MAJOR PROJECT ASSESSMENT:

***RESIDENTIAL, COMMERCIAL AND TOURIST
DEVELOPMENT AND ENVIRONMENTAL WORKS***

***OCEAN DRIVE, LAKE CATHIE
PORT MACQUARIE***

Director-General's
Environmental Assessment Report
Section 75I of the
Environmental Planning and Assessment Act 1979

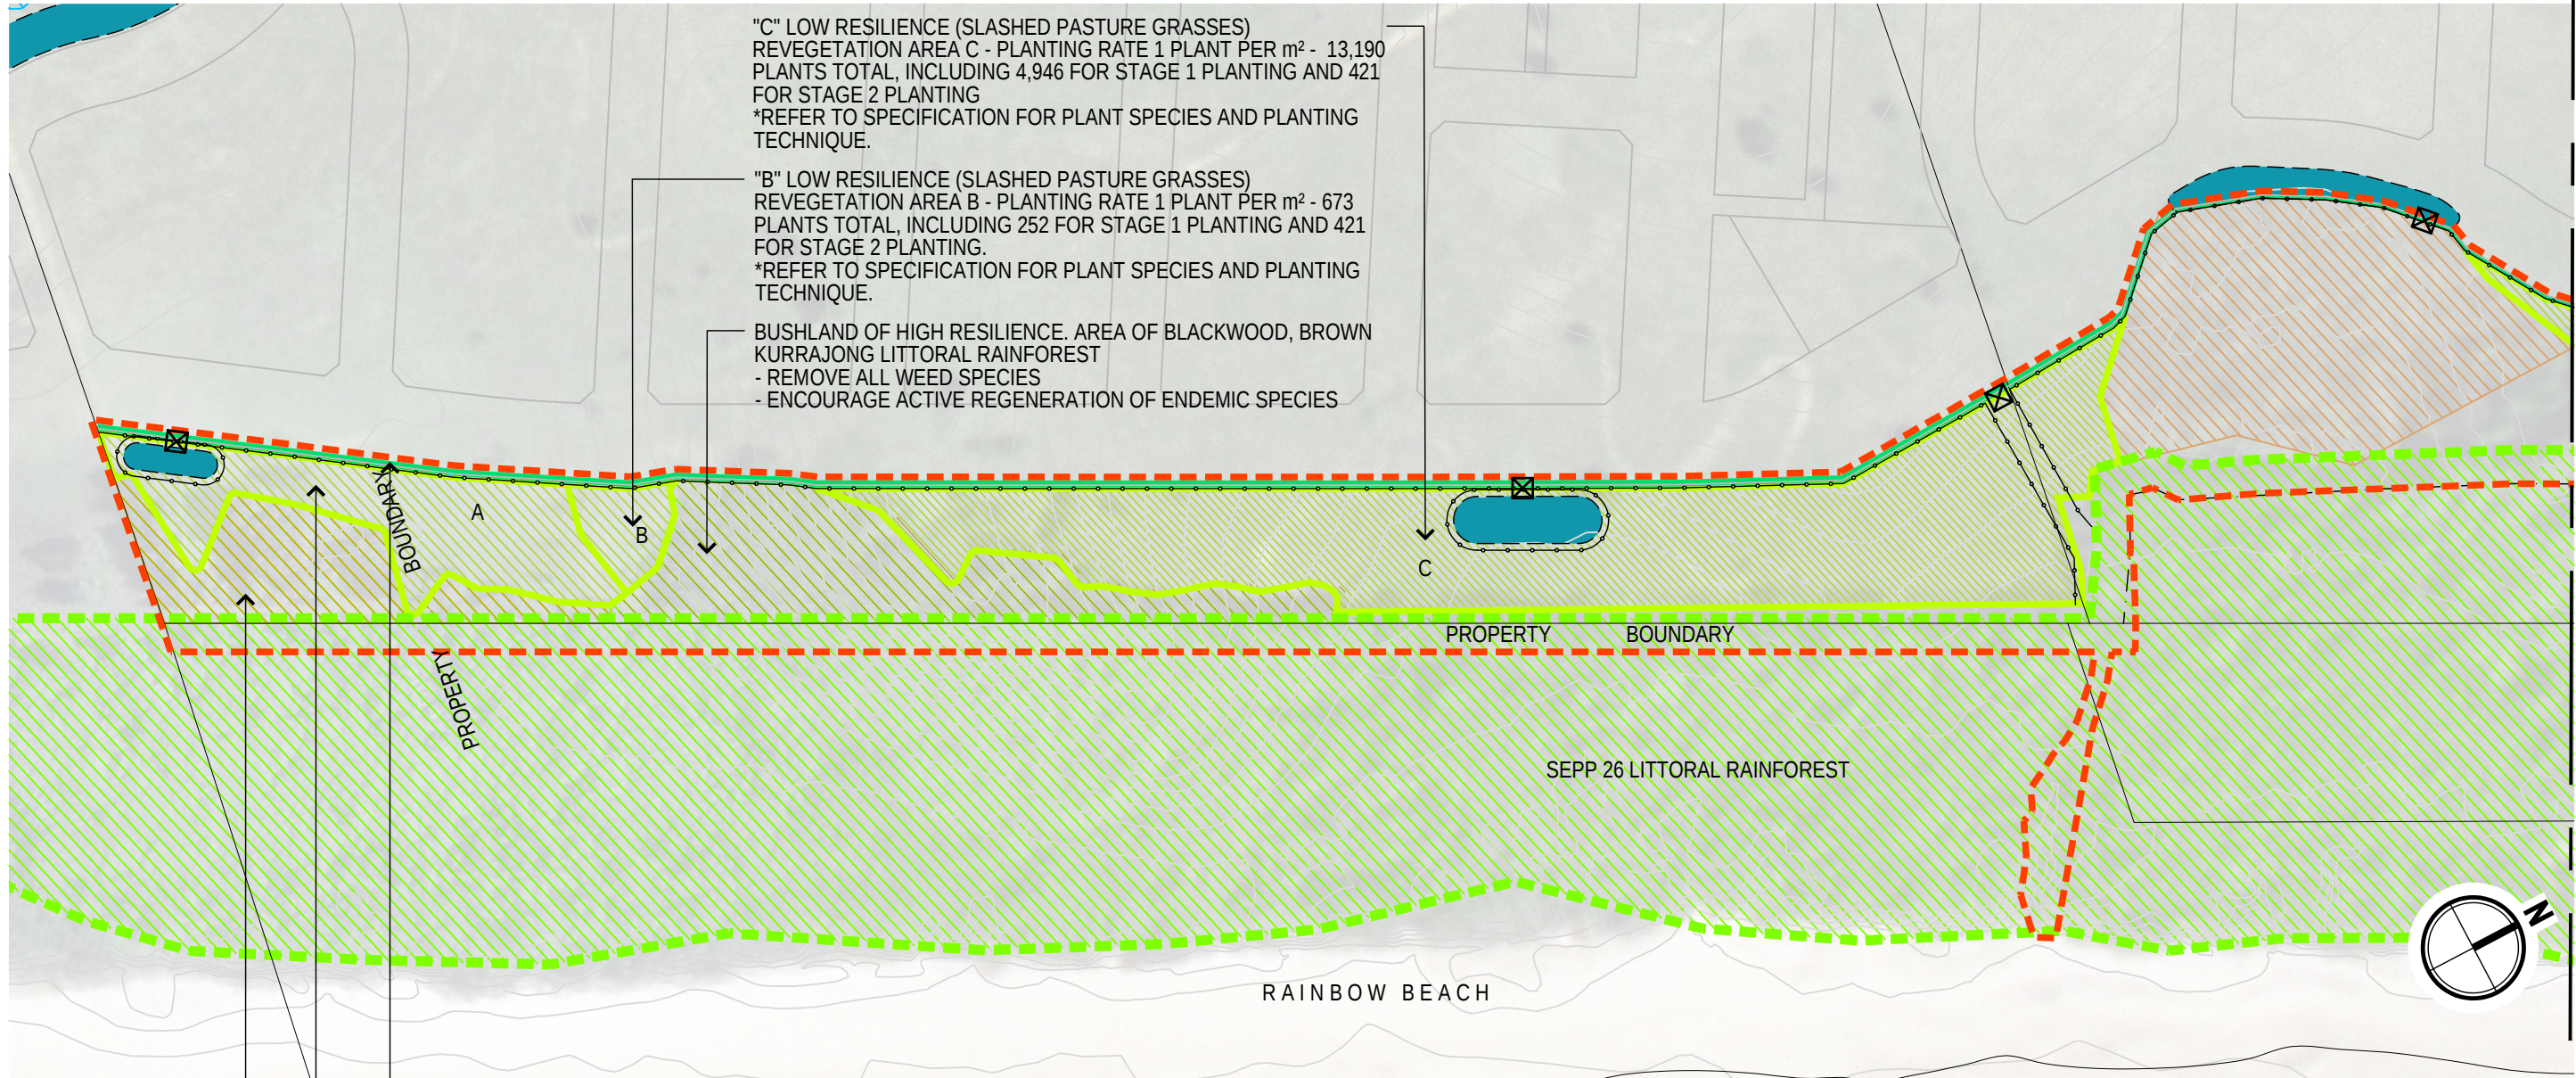
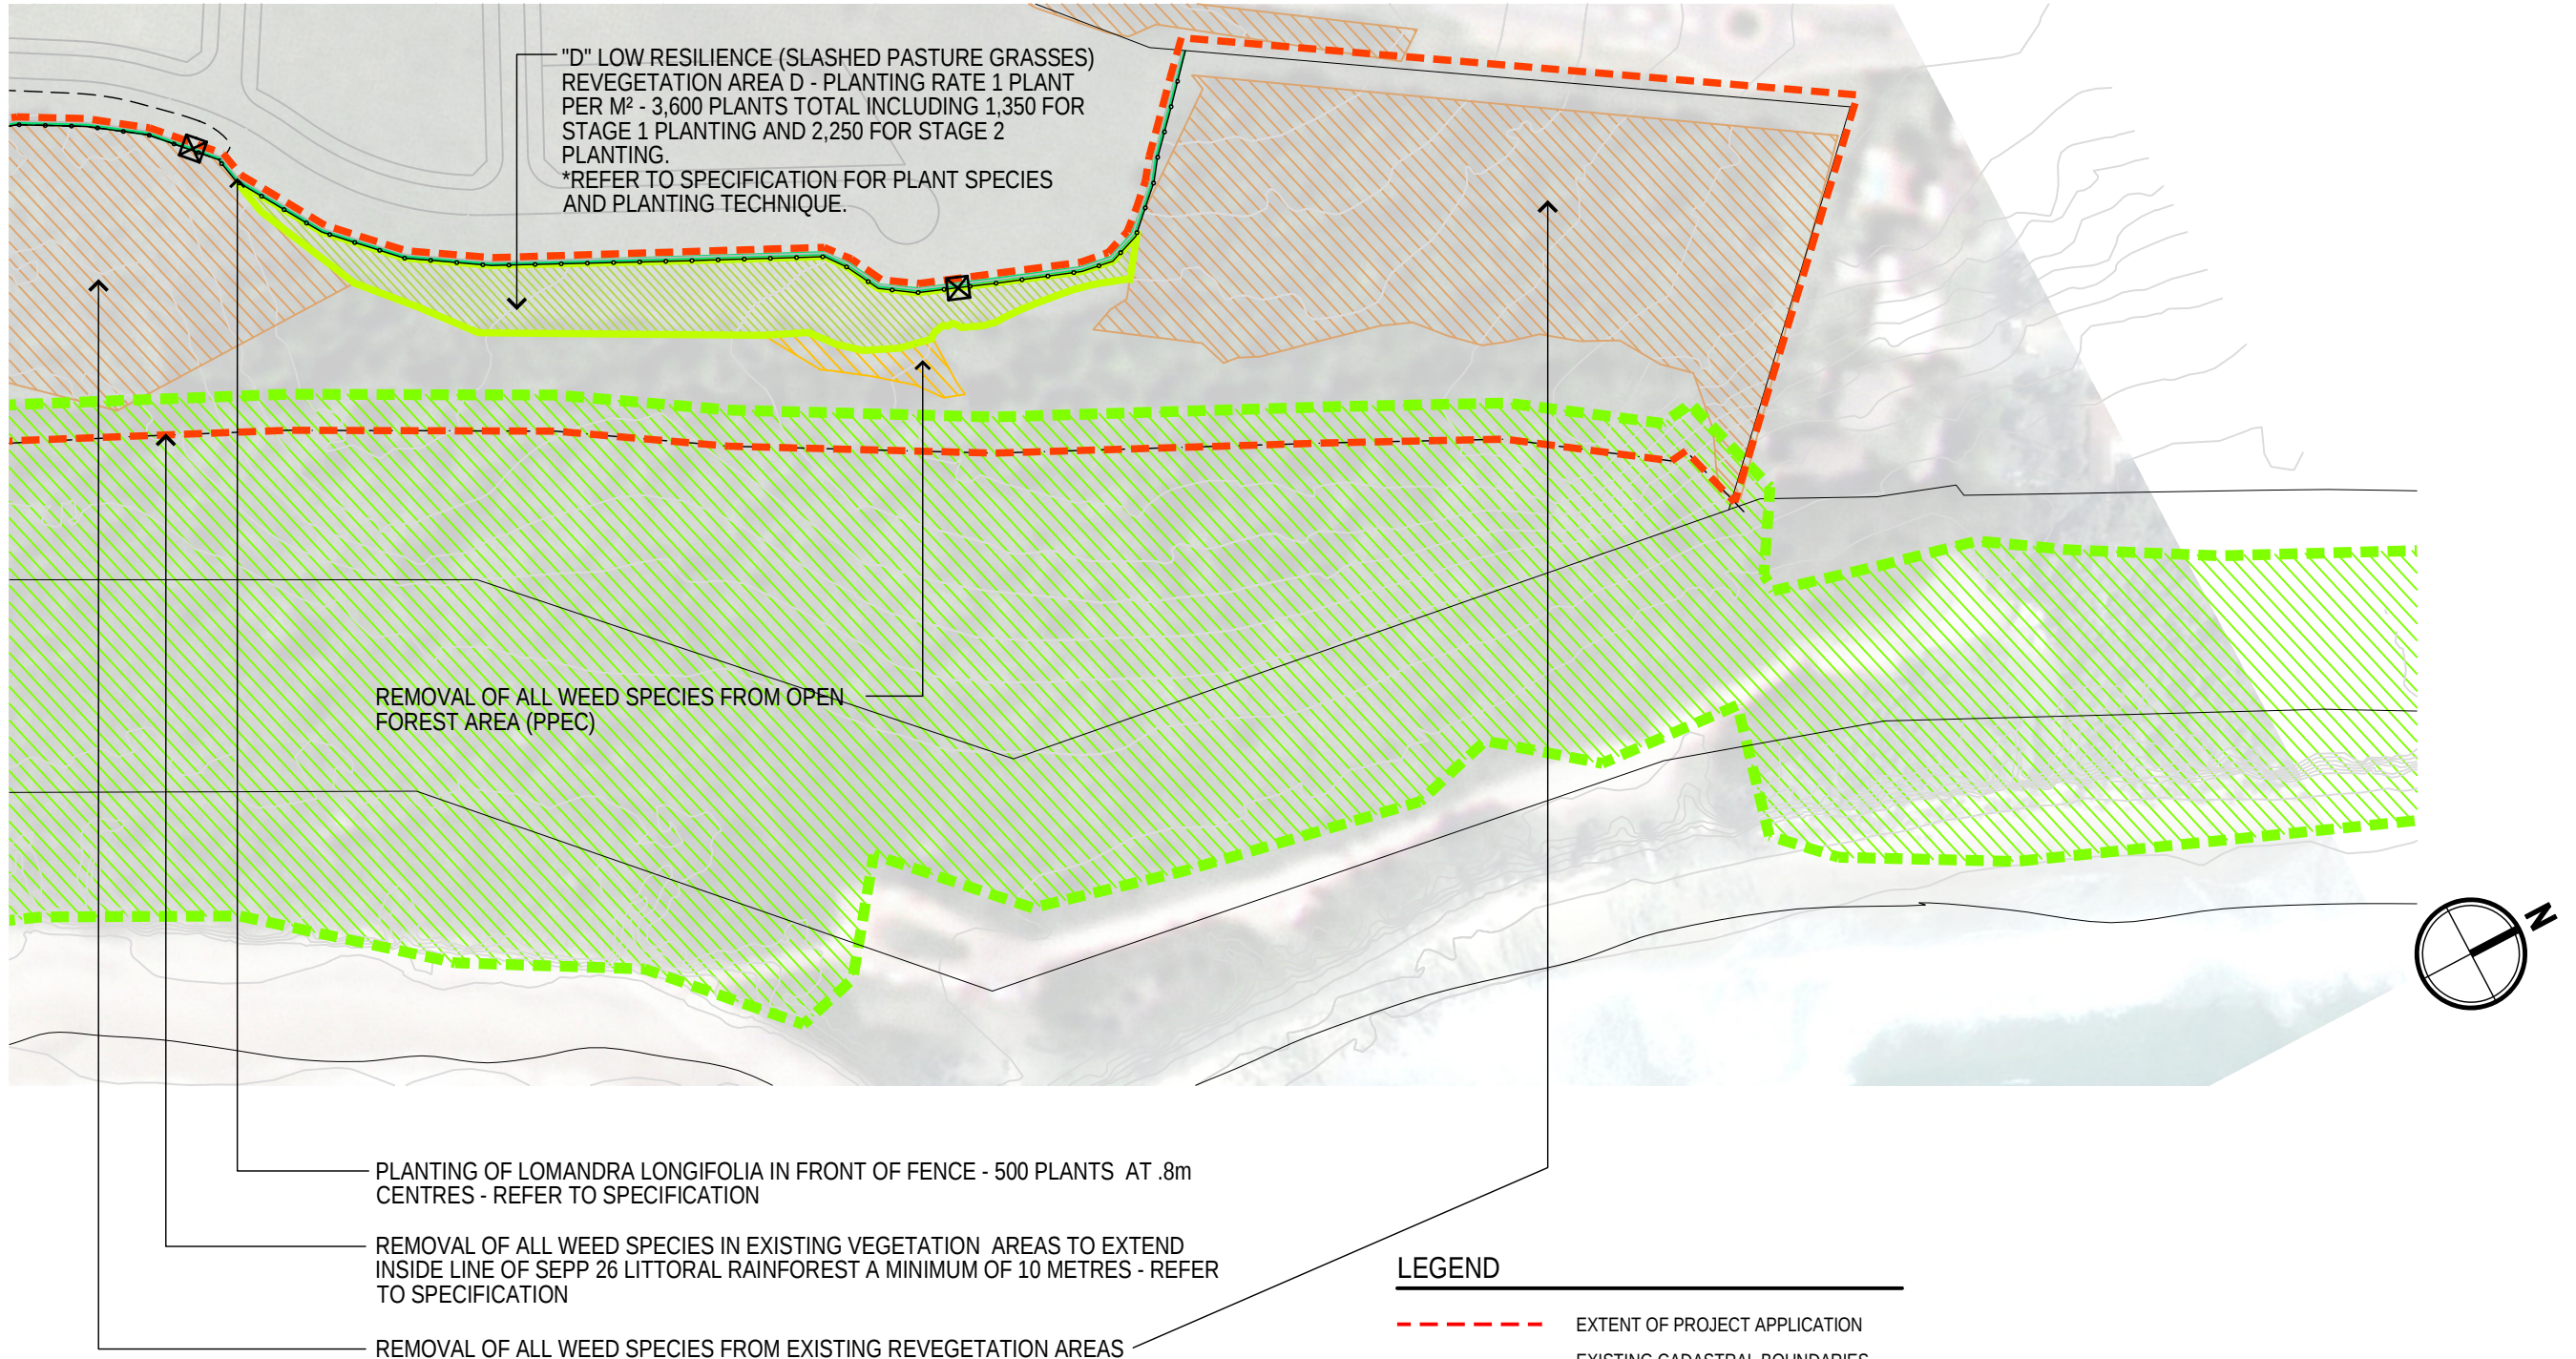
- *Vegetation Management* - the area of land subject to the Vegetation Management Plan was considered to be too small for the ongoing regeneration of the SEPP 26 Littoral Rainforest and should be extended eastward into the crown reserve up to the beach foreshore

- *Erosion Control* - an erosion control management plan be prepared for Duchess Gully
- *Vegetation Management* - the VMP include contingencies for failed plantings and unsuccessful weeding, 6 monthly weed inspections and a monitoring program

The above issues have been addressed either through project amendments or by way of project conditions. See Section 5.

Board and chain accessway (Coastal Dune Management, NSW Government 2007)

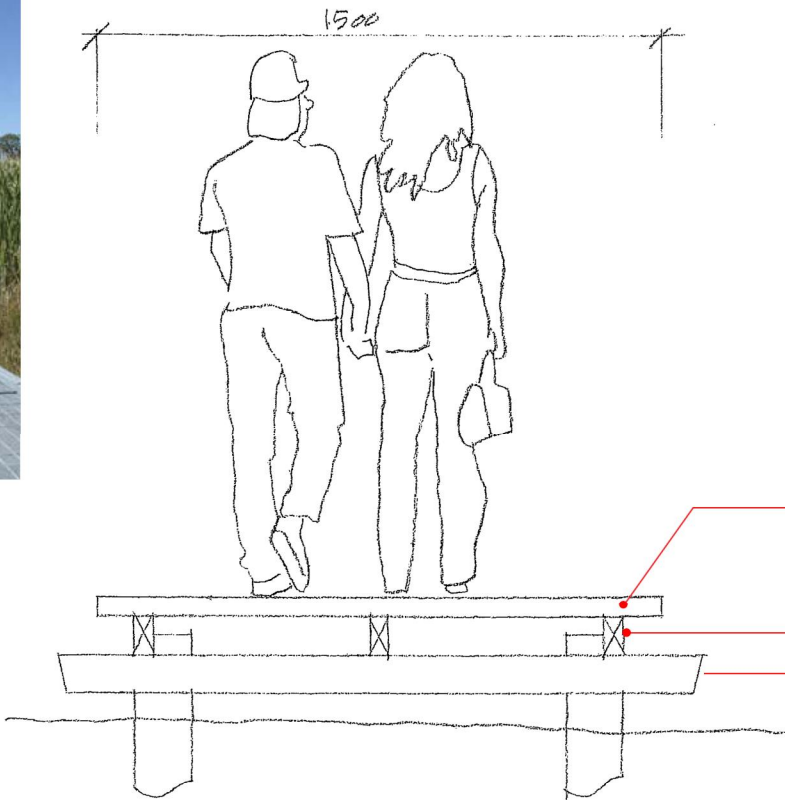
- *Boardwalk Design* - the boardwalk design be altered in its elevation and proposed materials to minimise damage to the littoral rainforest and to promote regeneration over time

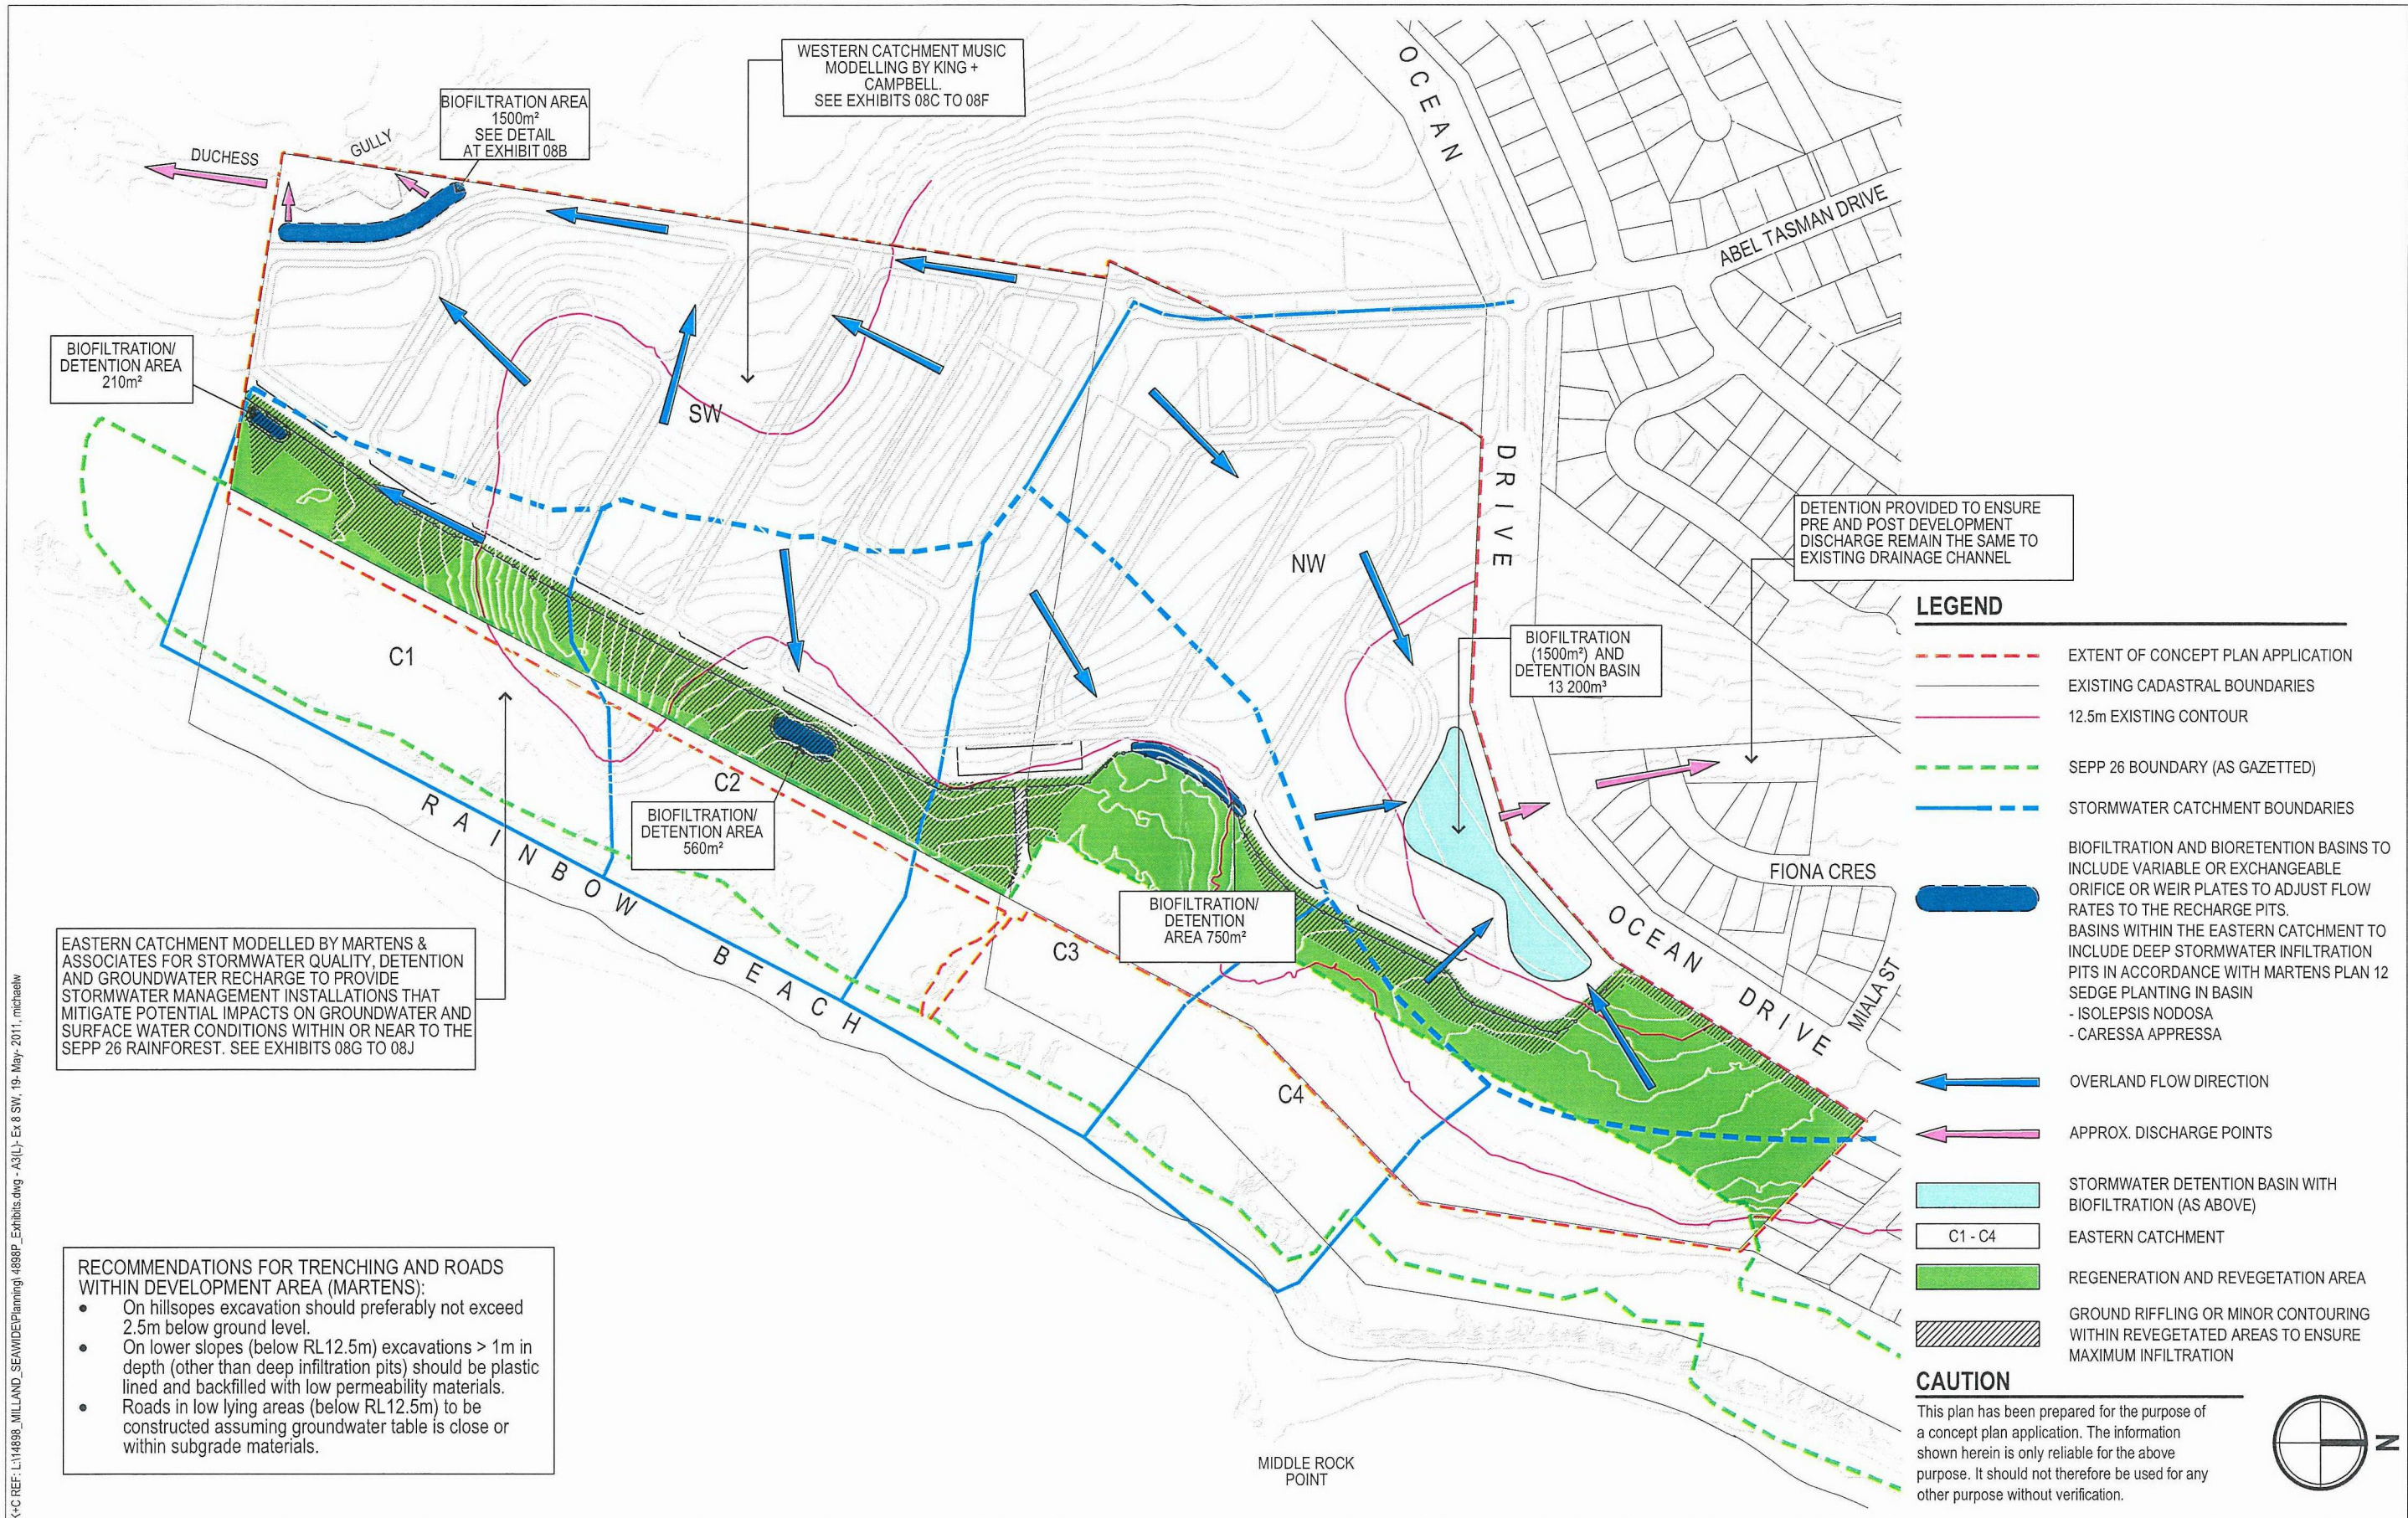
- *Stormwater* - the stormwater concept modelling for the north-west catchment of the site did not demonstrate that discharge rates would not exceed pre-development rates for all storm events up to and including the 100 year ARI event
